**KIRKLEES METROPOLITAN COUNCIL
INVESTMENT & REGENERATION SERVICE**

Reference No: 2020/62/90375/E

Site Address: 39, Lansdowne Close, Batley, WF17 0EZ

Description: Erection of summer house

BLOCK PLAN

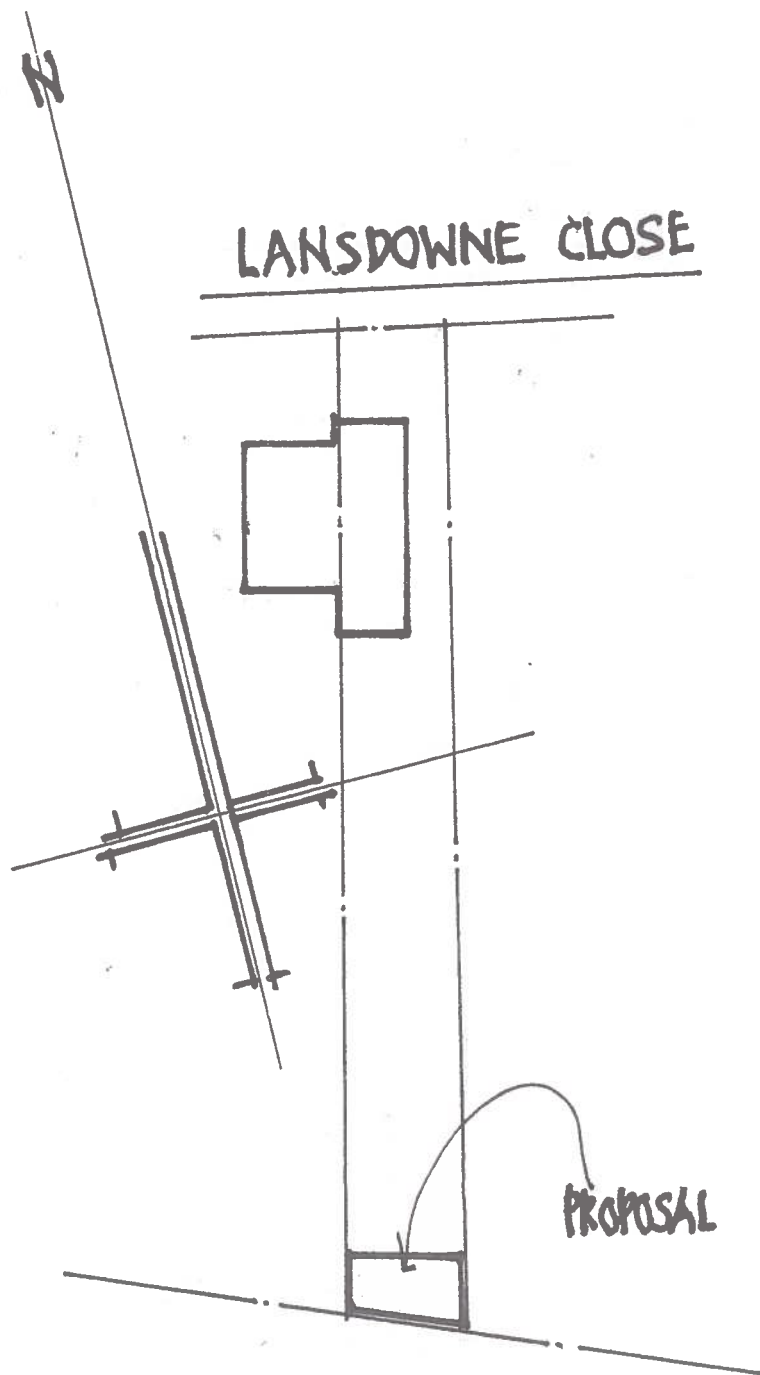
In this instance, in terms of scale the proposed summerhouse outbuilding has already been built at the bottom of the garden and fills practically the full width. However, it is a single storey structure with shallow pitched ridged roof, and compared to the elongated shape and size of the back garden, it is relatively small.

Although the summerhouse is close to the mutual boundary, it is located at the bottom of the garden, at least 25m from the back of this neighbouring house. In this location and given that it is a single storey structure, it has quite limited overshadowing or overbearing impact.

In this instance, whilst part of the summer house abuts the back boundary at this neighbouring property, given the summer house is single storey and orientated to the north, it would not have a significant overshadowing or overbearing impact. Furthermore it is some distance from the rear elevation of this neighbouring house with other structures in the intervening space and no openings in the facing rear or side elevations (new openings could also be controlled by condition), so in these circumstances there would be no invasion of privacy issues.
